**RE: Planning Application 22/01109/FUL**

**Demolition of Existing House and Outbuildings and Construction of Replacement House and Garage - High Ridge Top Street Askham Newark NG22 0RP**

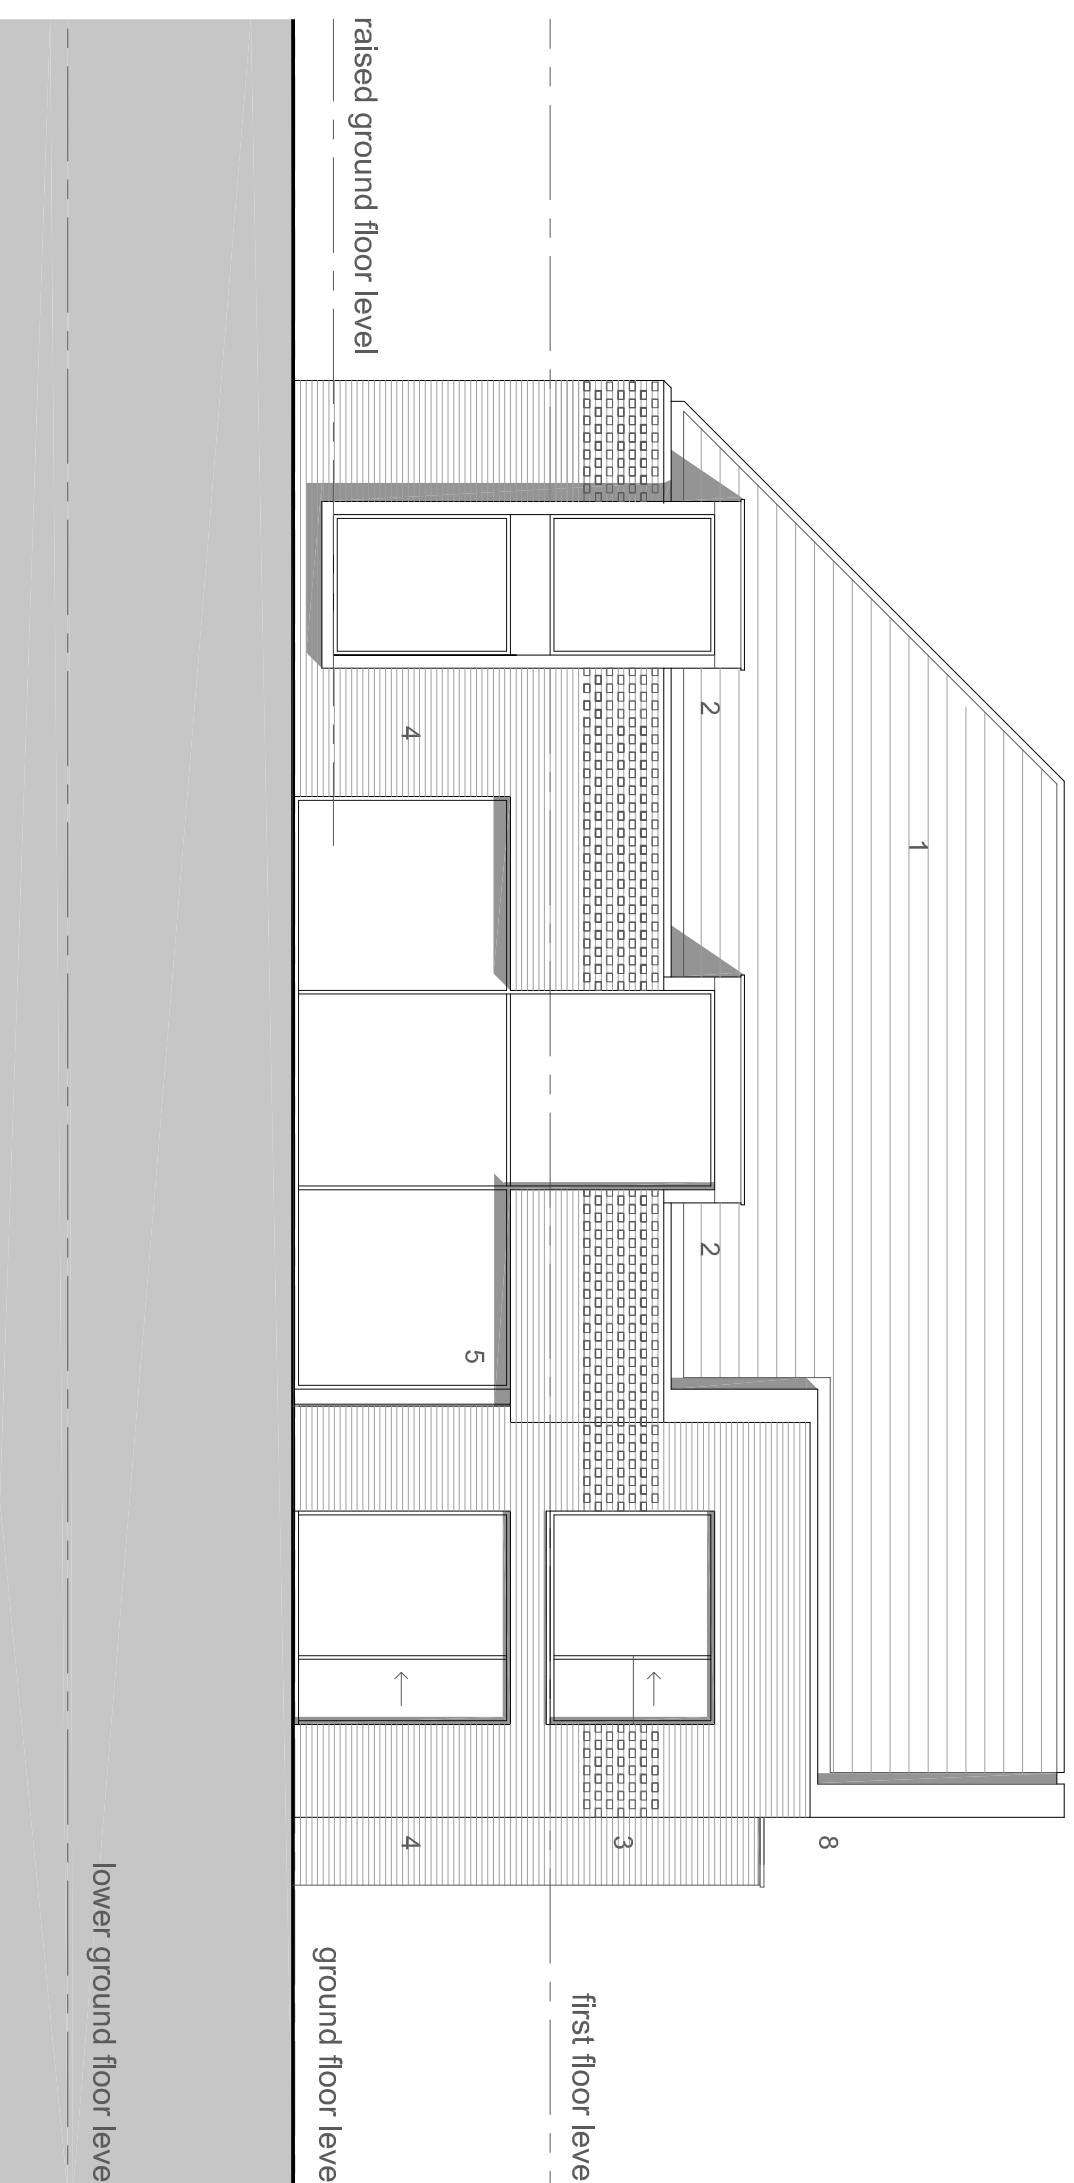
The size of the proposed construction is out of scale with neighbouring properties and extends far beyond the footprint of the original building. Increasing the building height from the existing bungalow to what is effectively a three-storey house will tower over the road and adjoining properties - especially considering the elevated natural landscape of the plot.

The proposed design is significantly larger than the existing baseline in all dimensions – twice the size in terms of footprint and three times the floor space. There is a proposed height increase of approximately 65%.

- 1) The demolition of The Coach House exposes our property. The existing window on High Ridge would overlook both our ground and first floor windows due to its elevated position. This includes a bedroom and living rooms.
- 2) The proposed additional storey, roof terrace and extensive use of contemporary glazing will increase this overlooking.
